**RE: Ladera and Unser Storage – Sector Development Plan Map Amendment, Site Plan for Subdivision, and Site Development Plan for Building Permit Project #1003274**

The purpose of this letter is to explain the modifications that have been made to the Site Development Plan for Subdivision and Site Development Plan for Building Permit for our project at the corner of Ladera Drive and Unser Boulevard. The project was approved by the Environmental Planning Commission (EPC) on August 11<sup>th</sup>, 2017.

**Conditions of Approval – 17EPC-40021 – Sector Development Plan Map Amendment**

**Conditions of Approval – 17EPC-40022 – Site Plan for Subdivision**

**FENCE 2 - BUILDING PERIMETER**

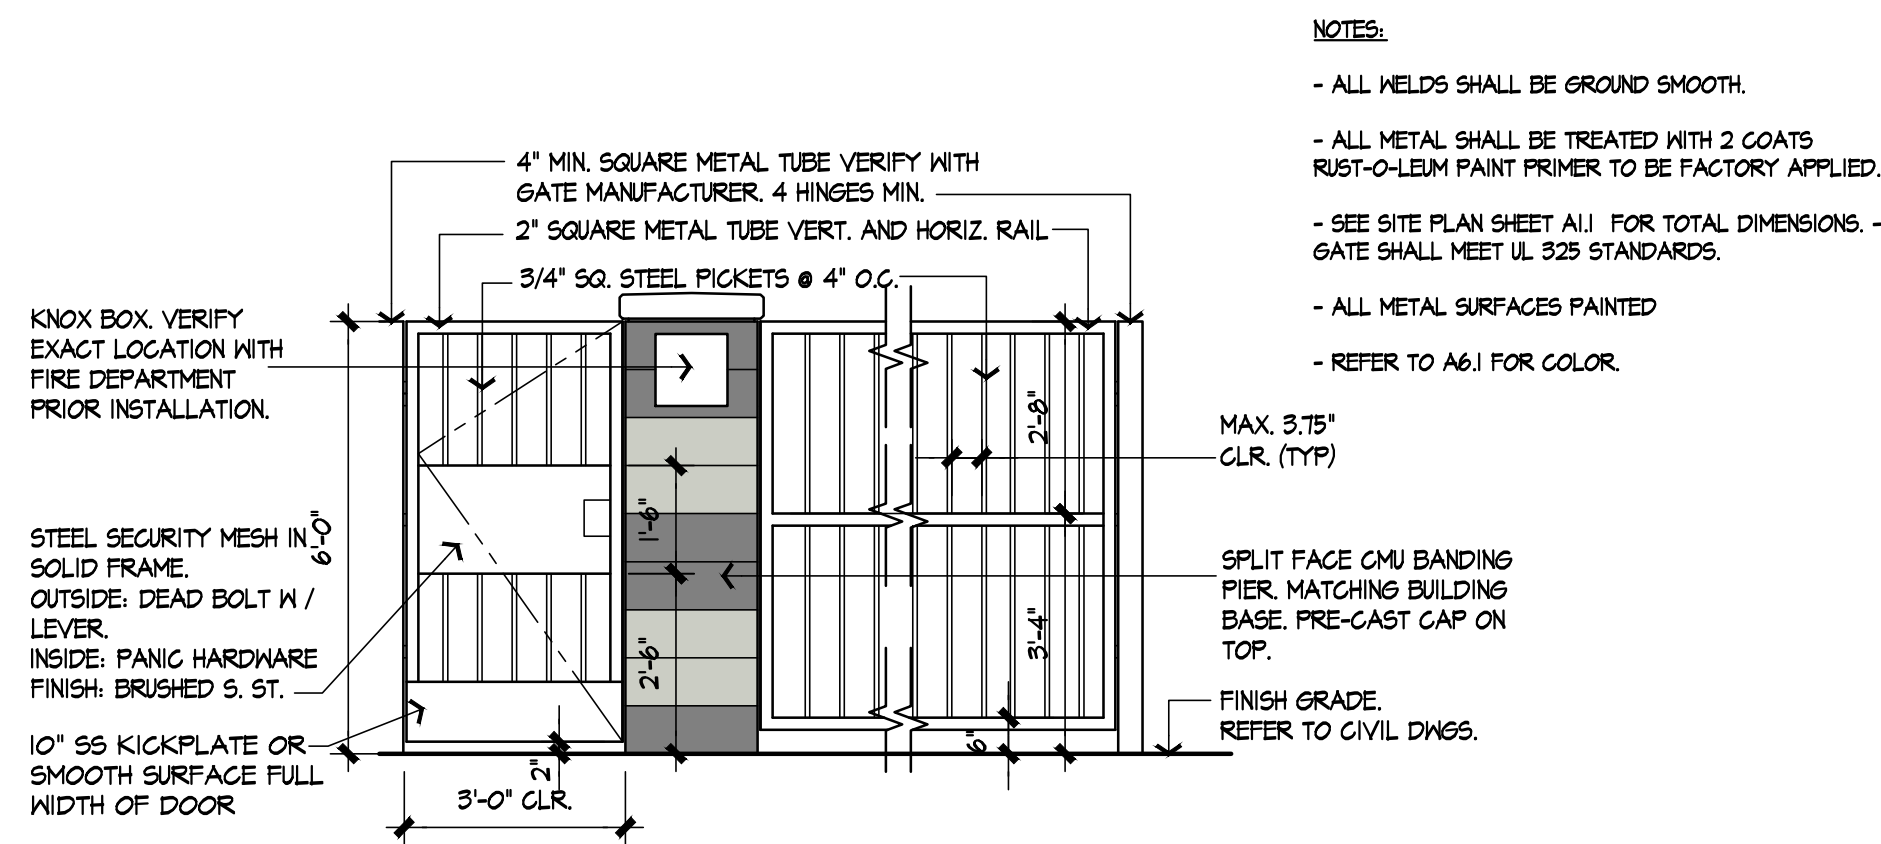
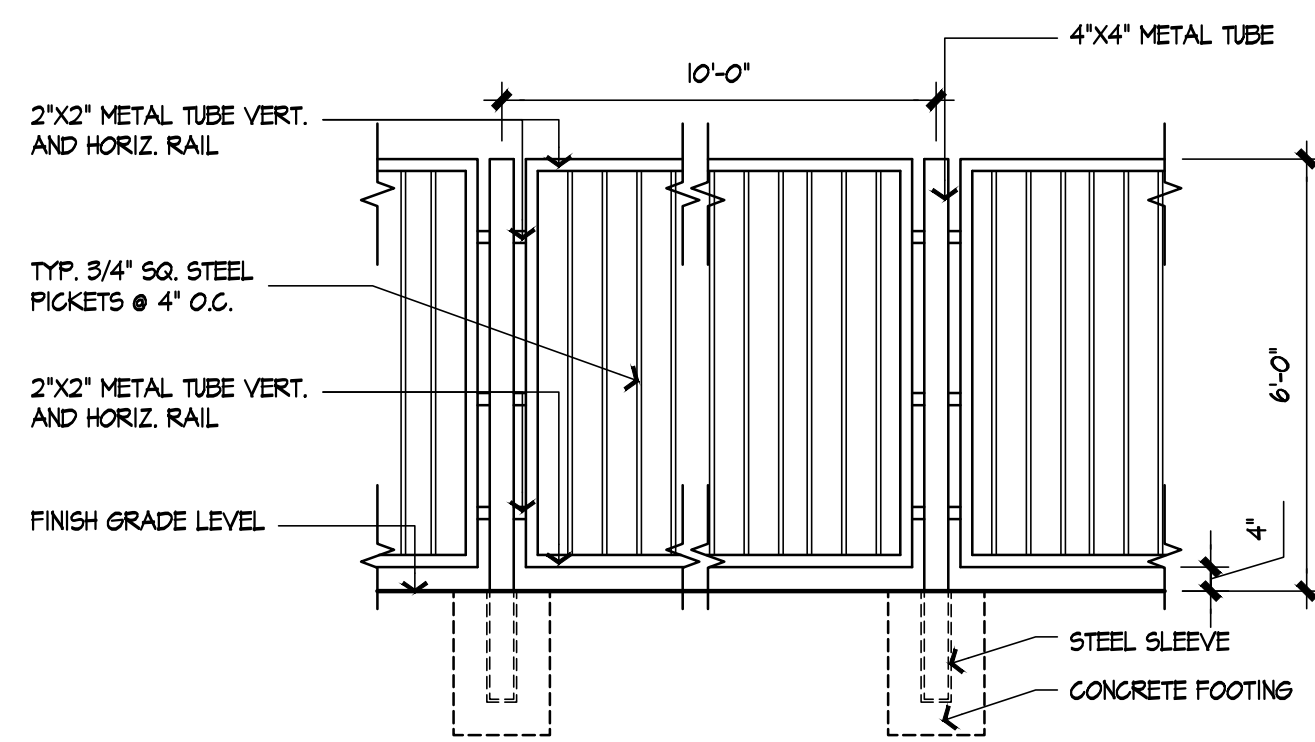
9. Details: provide details for the fence, gate, and seating.

*We have provided details for the fence and gate. We have also provided details for seating to be provided as part of the public outdoor space.*

**ACCESSIBLE PARKING DETAIL**

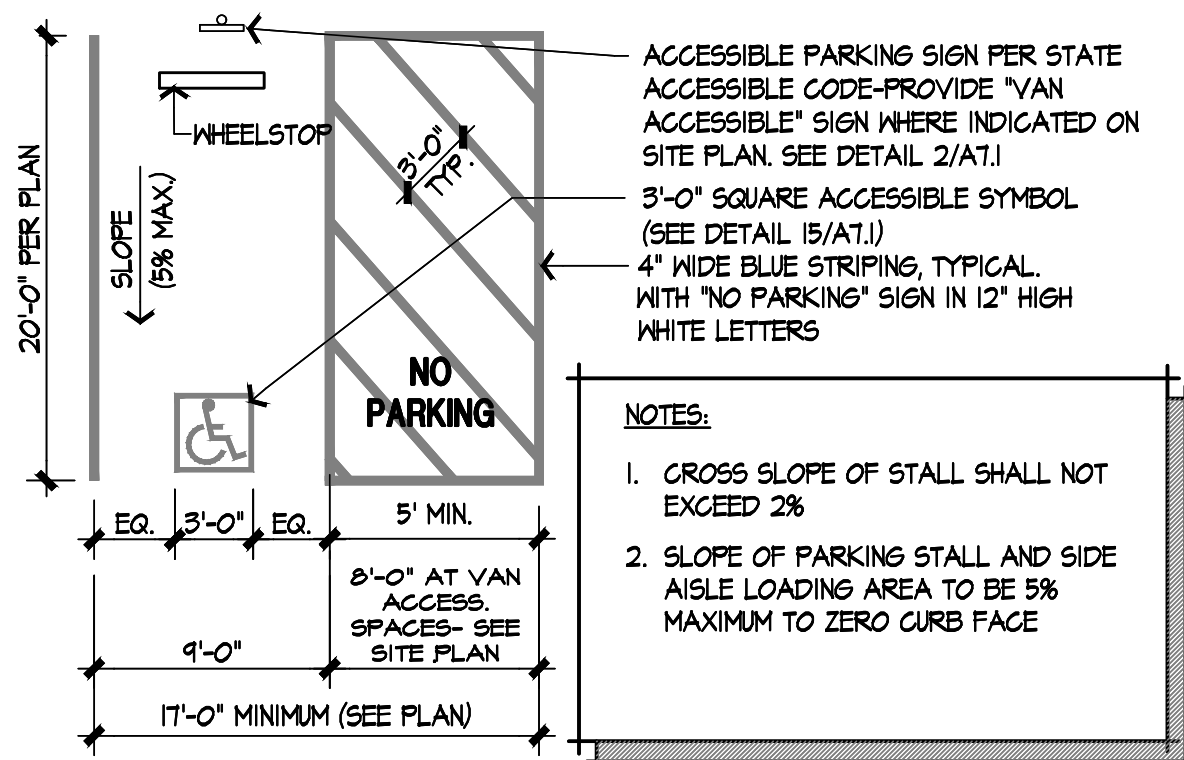
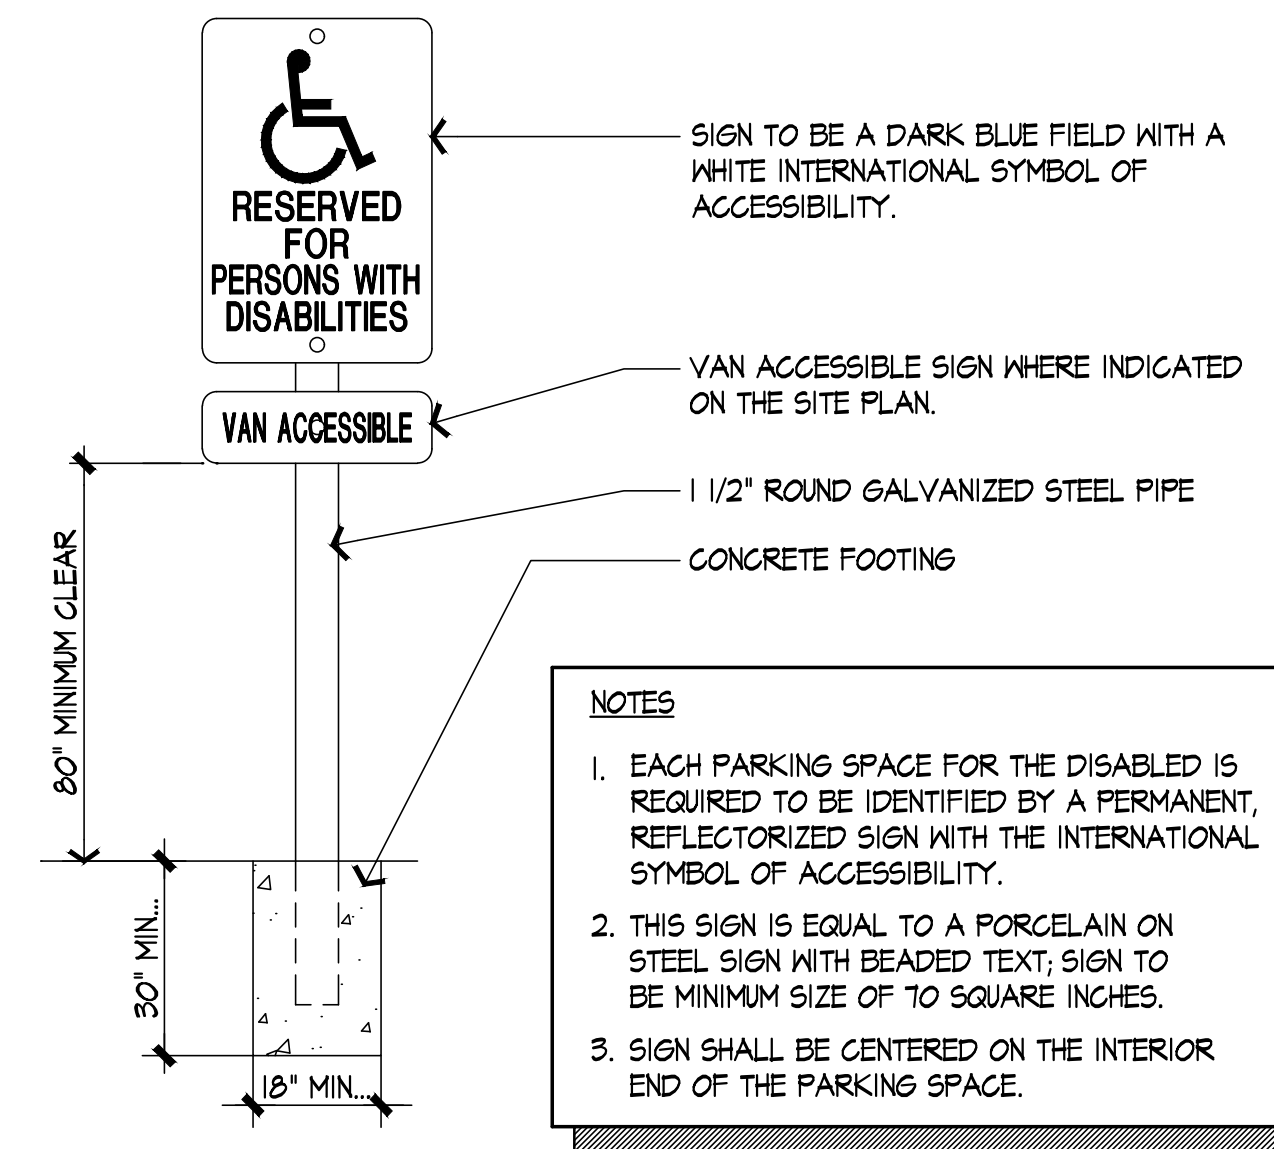
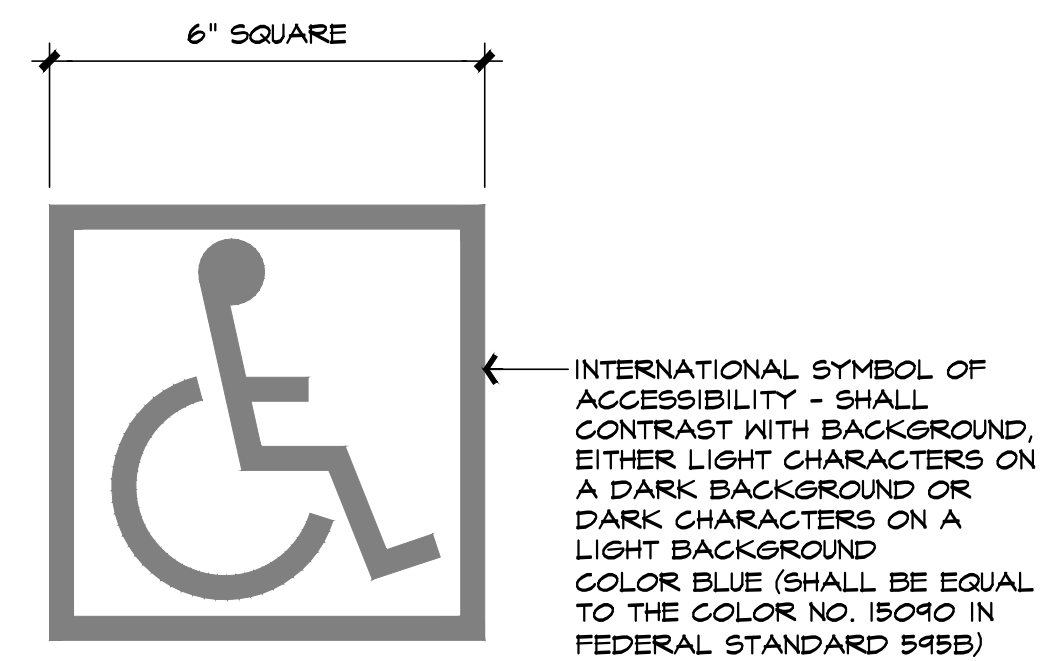
- The ADA accessible parking sign must have the required language per 66-7-352.4C NMSA 1978 "Violators Are Subject to a Fine and/or Towing." Please call out detail and location of HC signs.
- The ADA access aisles shall have the words "NO PARKING" in capital letters, each of which shall be at least one foot high and at least two inches wide, placed at the rear of the parking space so as to be close to where an adjacent vehicle's rear tire would be placed. (66-1-4.1.B NMSA 1978)

*Additional details have been provided that reflect the ADA sign and aisle requirements.*

**TRASH ENCLOSURE ENLARGED PLAN**

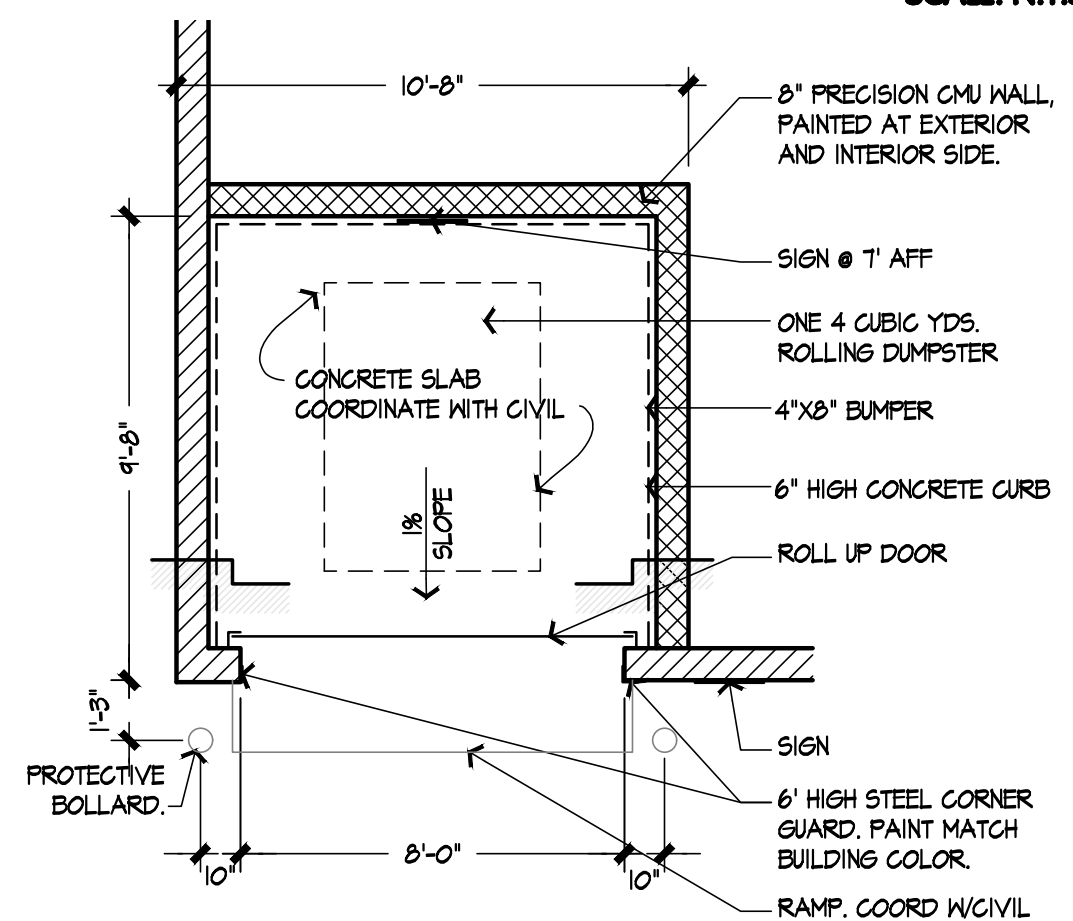
- The applicant shall work with Solid Waste to develop the specifications for the location and pick-up requirements for the project prior to DRB approval.

*The applicant has obtained approval from Solid Waste regarding the refuse location and truck access.*

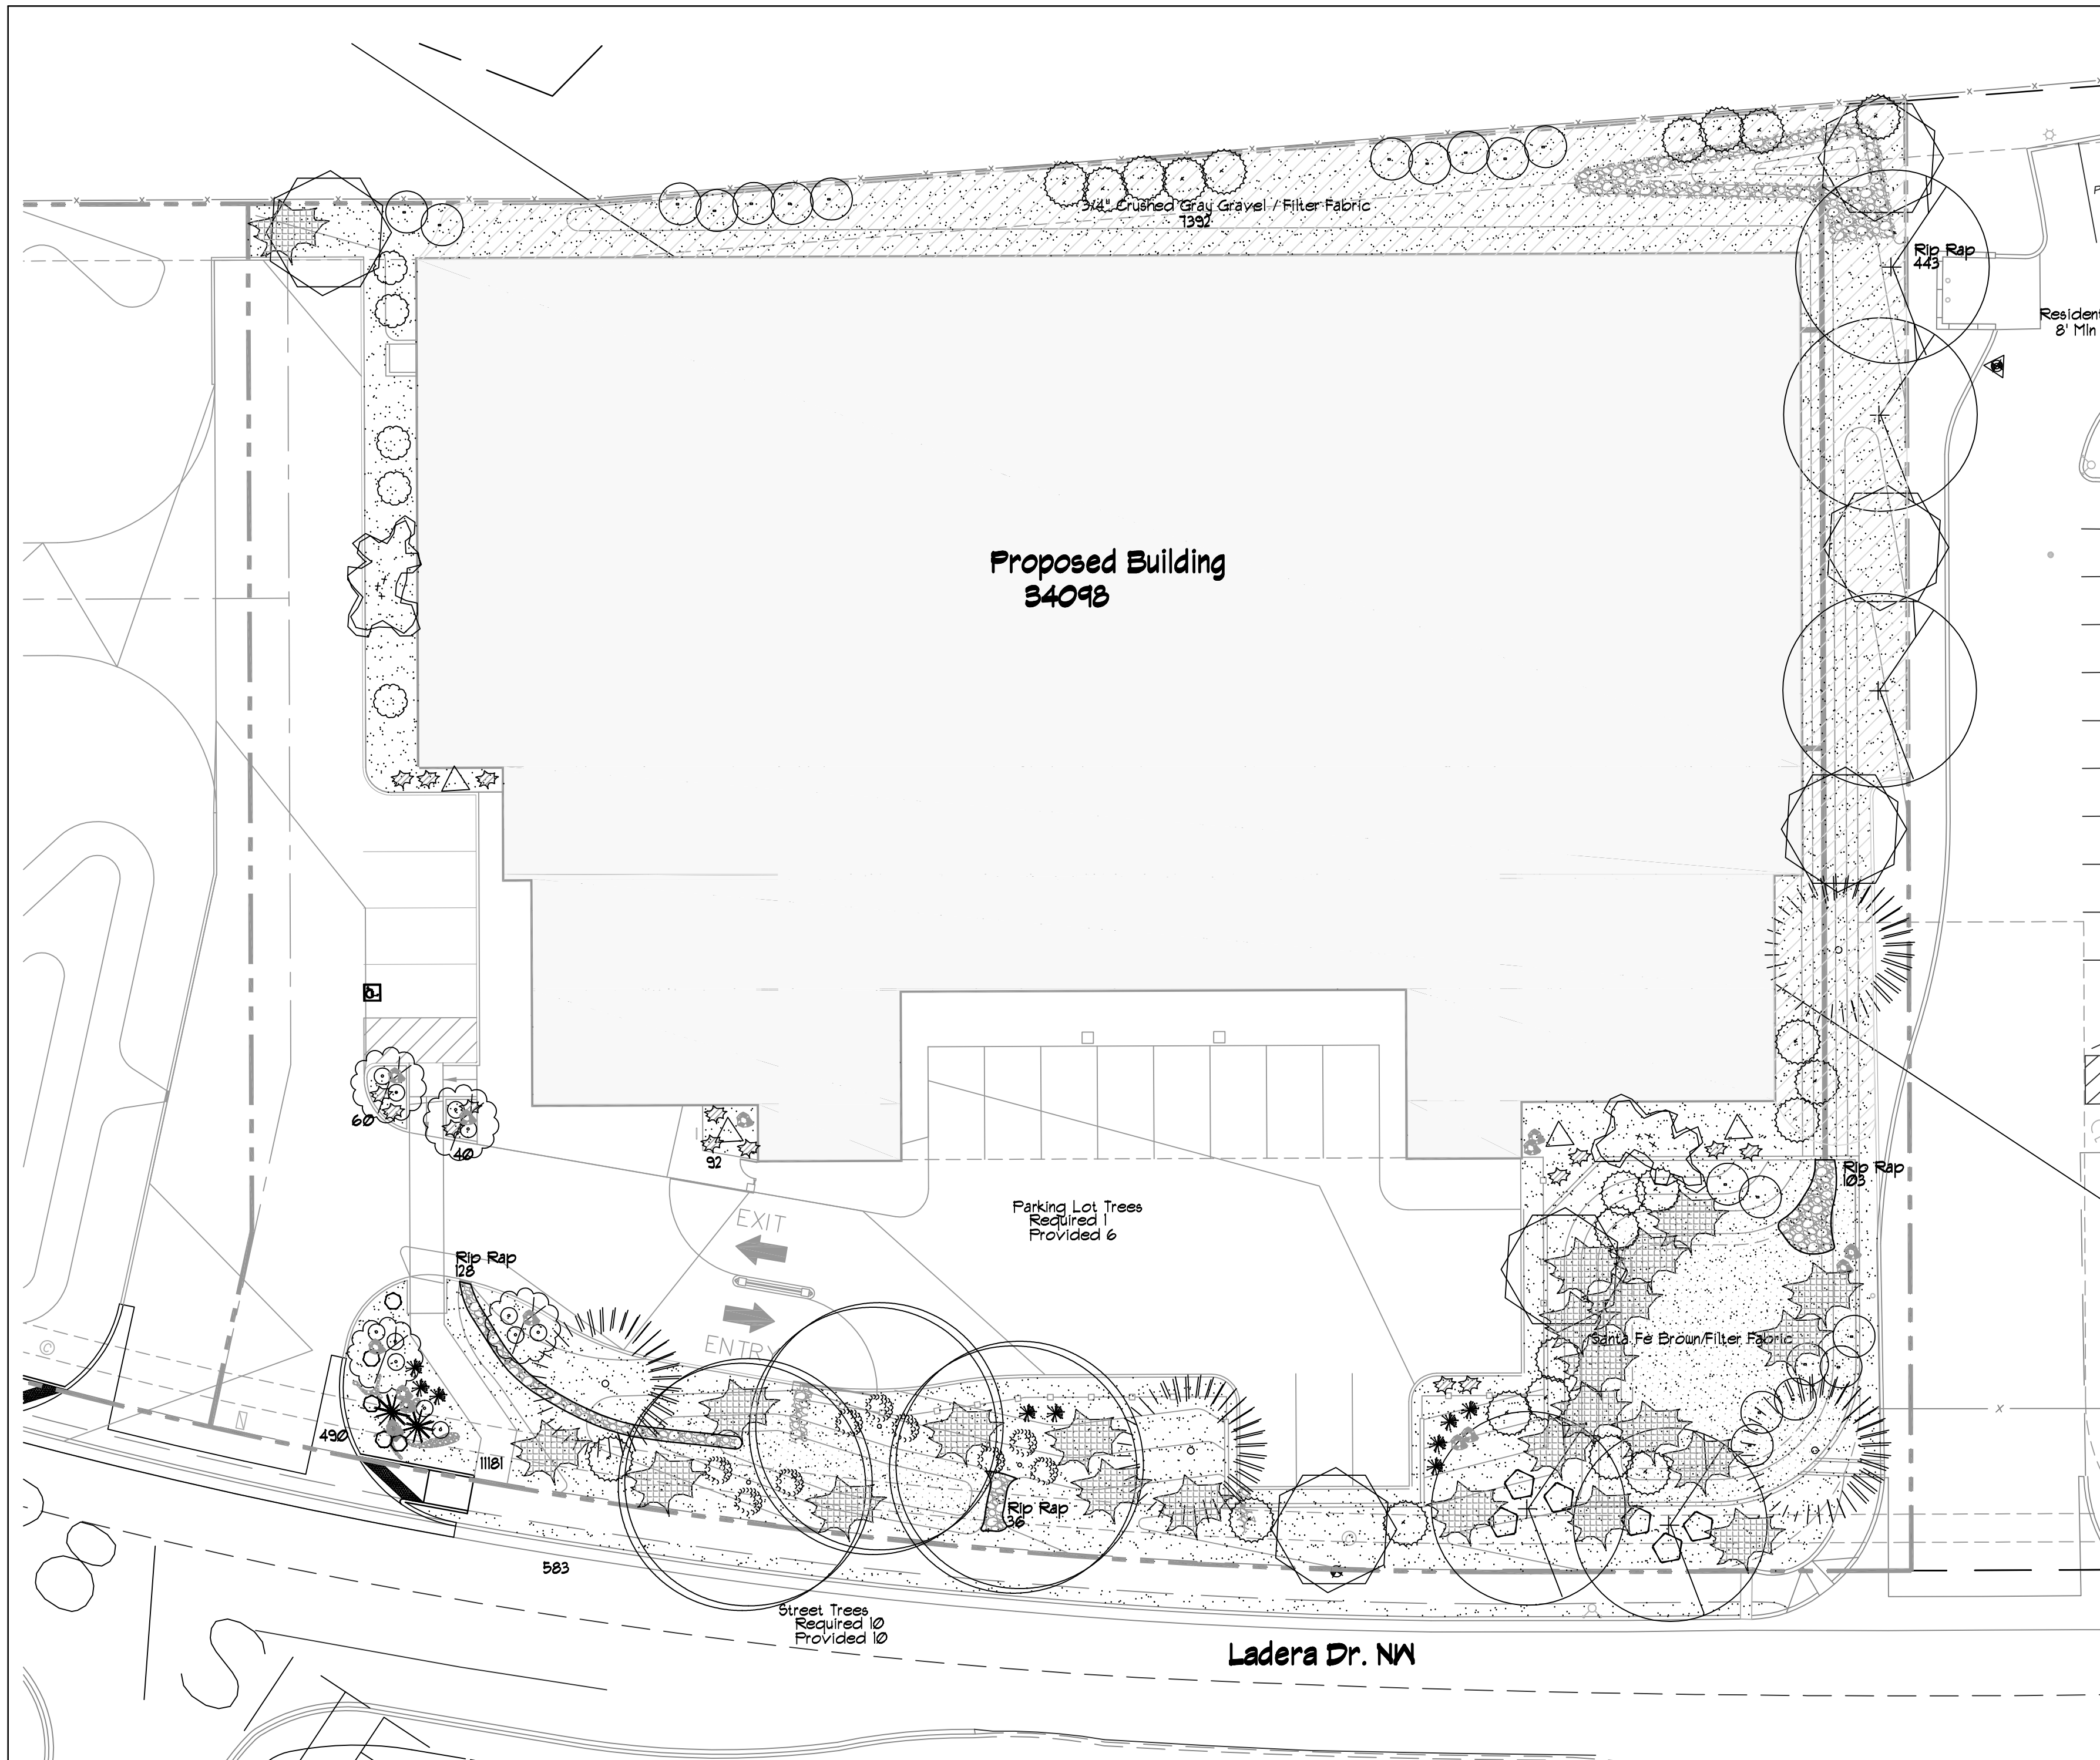
8. Per Zoning Code 14-16-3-10 (E) (8) (b), a buffer between commercial and residentially zoned properties with trees that are spaced 75% of the mature canopy diameter shall be provided.

*The Landscape Plan has been revised to provide the required buffer between the commercial and residential properties.*
